In response to the Armidale BESS (SSD-23515853) *Amendment Report (July 2025)*, *consolidated response to RFIs* and updated *Addendum Traffic Impact Assessment (dated 18 July 2025)*, Council provides the following advice:

SSD-23515853, Armidale Battery Energy Storage System; Response to addendum Traffic Impact Assessment, Request for further information

SSD-23515853, Armidale Battery Energy Storage System; Response to addendum Traffic Impact Assessment, Request for further information

Figure 1: Pinch Point – OSOM vehicle traversing over median island at Jerry Plains Road off-ramp and Putty Road. Source: Drawing No. EMM-009 – Armidale Battery Energy Storage System OSOM assessment - Appendix A swept path assessments

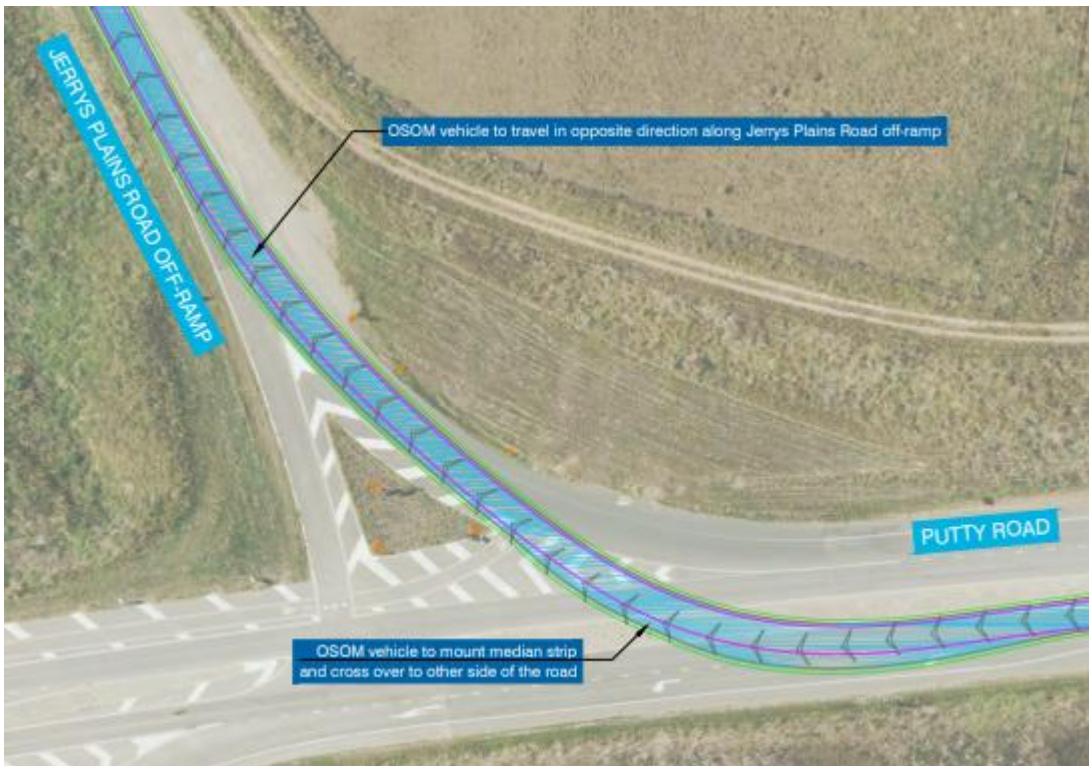
No.	TfNSW comments from RtS and Amendment response requiring RFI	TfNSW response to RTS, Amendment Report or RFI and request for further information for revised TIA
1	Provide a diagram of the laden dimensions, including the heights, widths, weights, and lengths of the check vehicle and load for the high-risk OSOM.	CLOSED: Diagram of high-risk vehicle provided.
2	Turn from Golden Highway onto Mount Thorley Road. The entry ramp appears close to the edge of the pavement. Provide a swept path analysis demonstrating that 0.5 m can be achieved from the wheel path to the edge of the pavement for this location.	CLOSED: Golden Highway onto Mount Thorley Road is not proposed to be used as part of the high-risk OSOM route.

Figure 2: Pinch Point – OSOM vehicle traversing over median island at New England Highway/ Scott Road, Tamworth. Source: Drawing No. EMM-023 – Armidale Battery Energy Storage System OSOM assessment - Appendix A swept path assessments

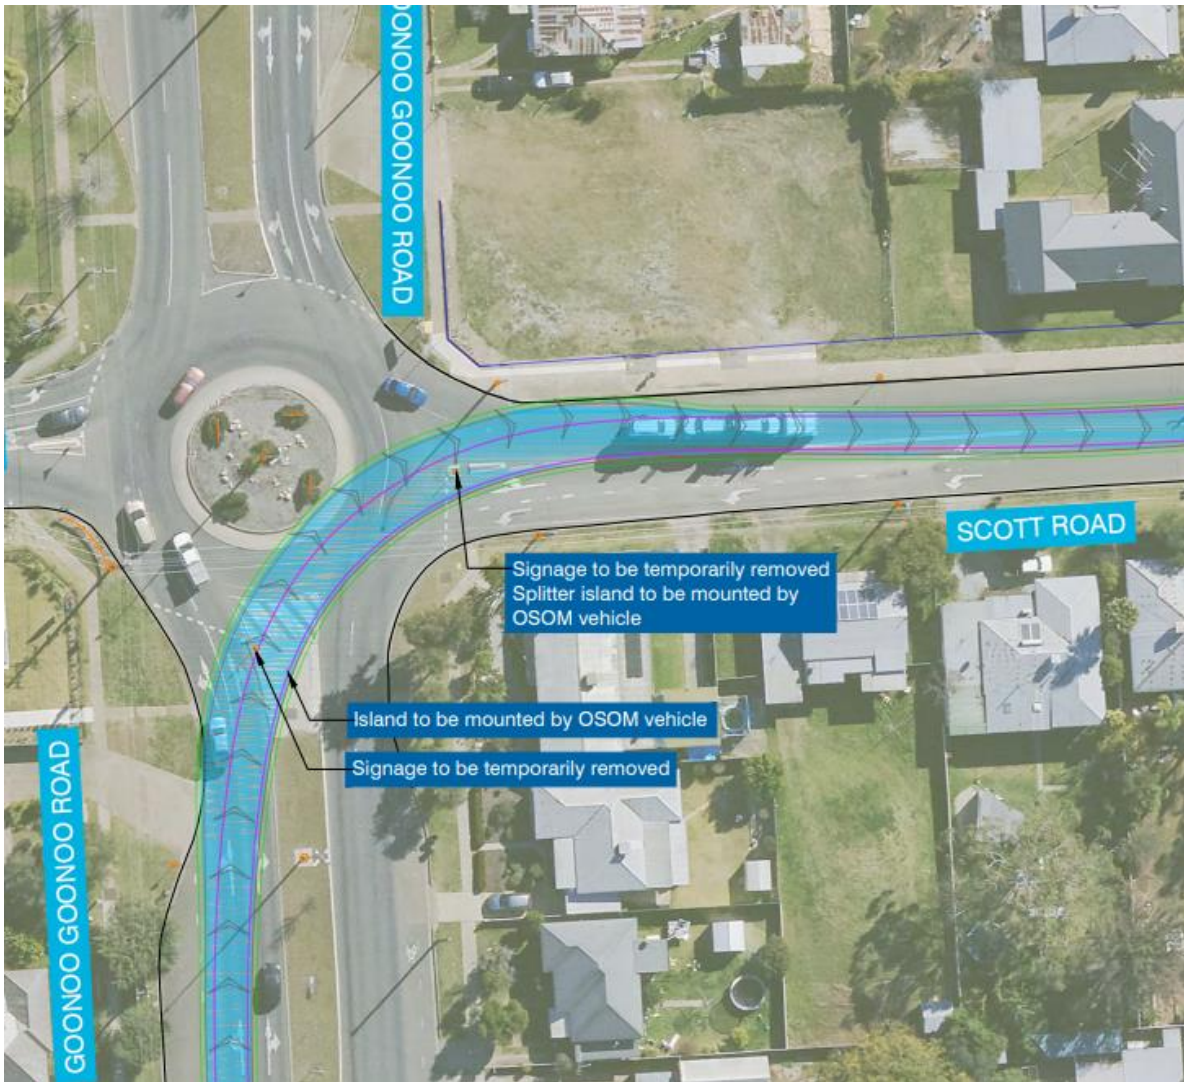
<p>6</p>	<p>Strategic concept designs are to be prepared and included within the revised TIA for the road works proposed to the centre islands of the New England Highway/Oxley Highway, which are identified within the route analysis as a requirement for the high-risk OSOM-laden vehicle configuration to navigate this pinch point</p>	<p>OPEN:</p> <p>Armidale BESS proposes to traverse median or refuge island at 6 locations on the state road network (see figures within Attachment B for locations), using a rubber mat and steel protection method to safeguard the medians. This method cannot be supported by TfNSW.</p> <p>The revised TIA is to detail the scope of the modifications to the median(s) required to ensure that the high-risk OSOM can negotiate the pinch point(s) on the state road network without damaging the state road infrastructure.</p> <p>If traversing of the medians on the state road network cannot be avoided, then strategic concept designs will be required that identify the scope of the works that would be necessary to ensure the median could be traversed and withstand the mass of the high-risk OSOM movement (i.e pavement strengthening). Strategic concept designs will need to be submitted to identify the extent of the road upgrades, or provide a strategic concept design that identifies the temporary or partial removal of the median, in accordance with Austroads and TfNSW requirements, that will allow for the high-risk OSOM to navigate through this pinch point.</p> <p>Note: Temporary removal will need to include the length of time for removal, any interim treatments (e.g., line marking), and when and what will replace the median post-completion of high-risk OSOM movement. Alternative options to avoid traversing the state road network infrastructure include changing the route or modifying the high-risk OSOM vehicle configurations.</p> <p>Note: TfNSW advises that changing the route and changing the vehicle configuration of the high-risk OSOM could potentially increase the scope of works required on the public road network.</p>

Figure 4: Pinch Point – OSOM vehicle traversing over refuge island at Kentucky Street, Armidale. Source: Drawing No. EMM-031 – Armidale Battery Energy Storage System OSOM assessment - Appendix A swept path assessments

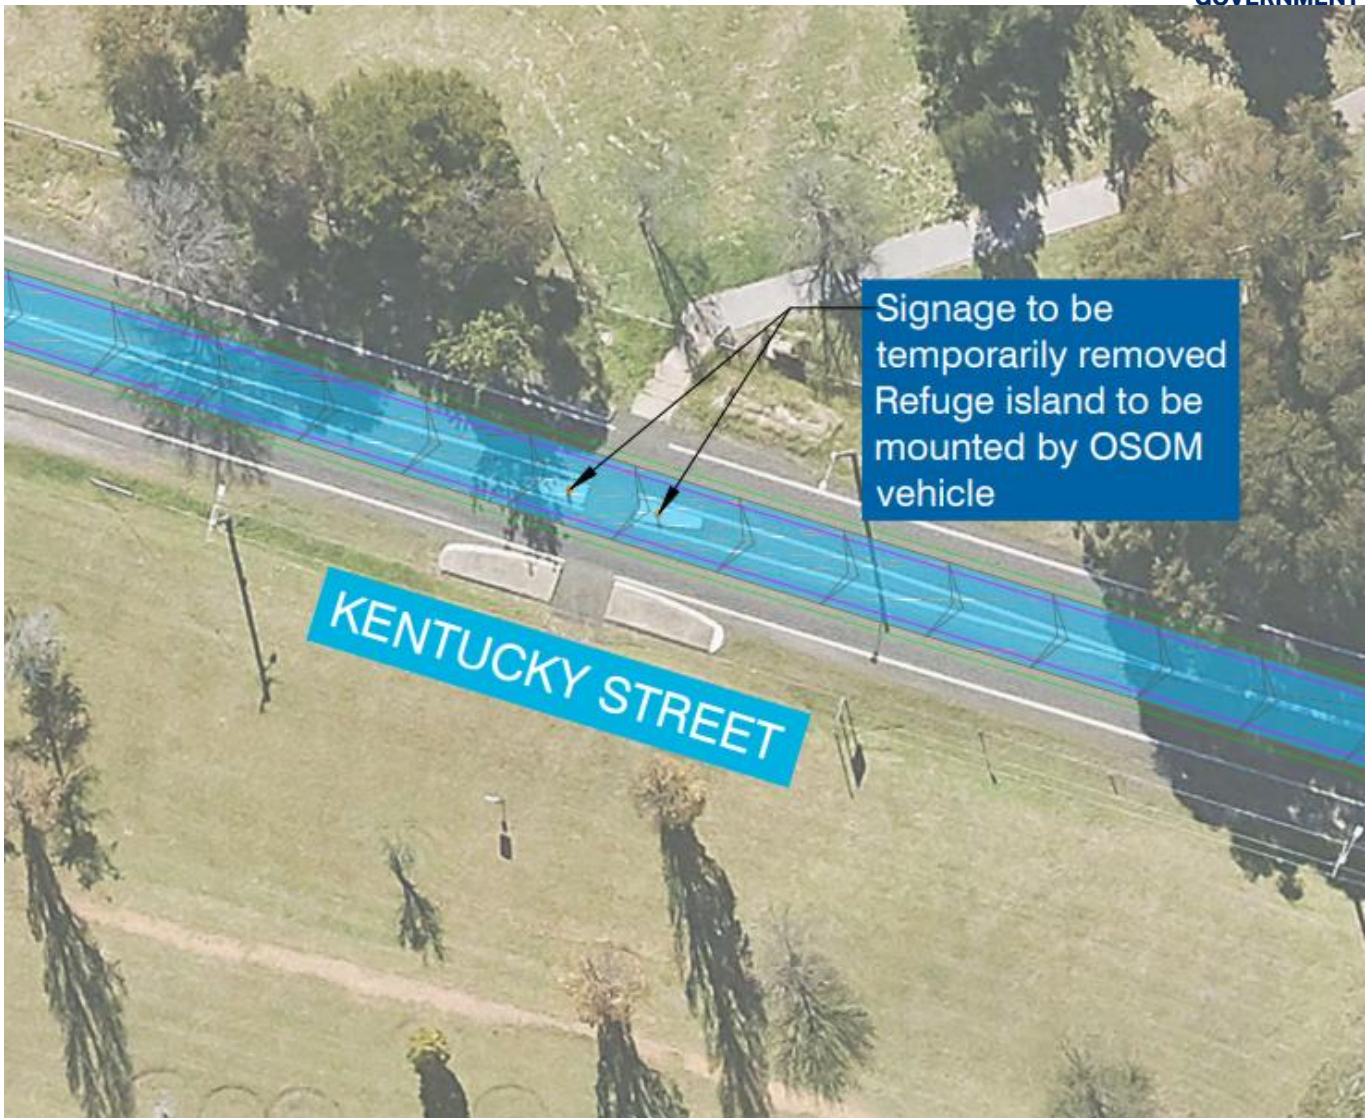
7	<p>Strategic concept designs are to be prepared and included within the revised TIA for the road works proposed to the centre islands of the Waterfall Way/ Canambe Street, which are identified within the route analysis as a requirement for the high-risk OSOM-laden vehicle configuration to navigate this pinch point.</p>	<p>CLOSED:</p> <p>The report states that hardstands required at the Waterfall Way/Canambe Street roundabout and that the design will be to TfNSW standards. The impacted kerb, grassed road reserve and footpath at that location are Council assets so it will be for Council to determine the requirements</p>
8	<p>The project proposes to use the route via Sydney Road and under the rail underpass through Muswellbrook. The rail underpass has height and horizontal geometric limitations, such as barriers and other infrastructure, that need to be reviewed to assess whether traversing underneath the rail overpass on Sydney Road would be a viable option as a high-risk OSOM route based on the project-laden height, width, and length for the high-risk OSOM-laden vehicle configuration. TfNSW notes that the route analysis has considered the alternative route via Bell Street. TfNSW requires point 7 to be addressed and confirm whether both options will continue to form part of the project's high-risk OSOM routes through Muswellbrook.</p>	<p>CLOSED:</p> <p>The high-risk OSOM route analysis no longer includes the use of Sydney Road within Muswellbrook, as part of the route.</p>
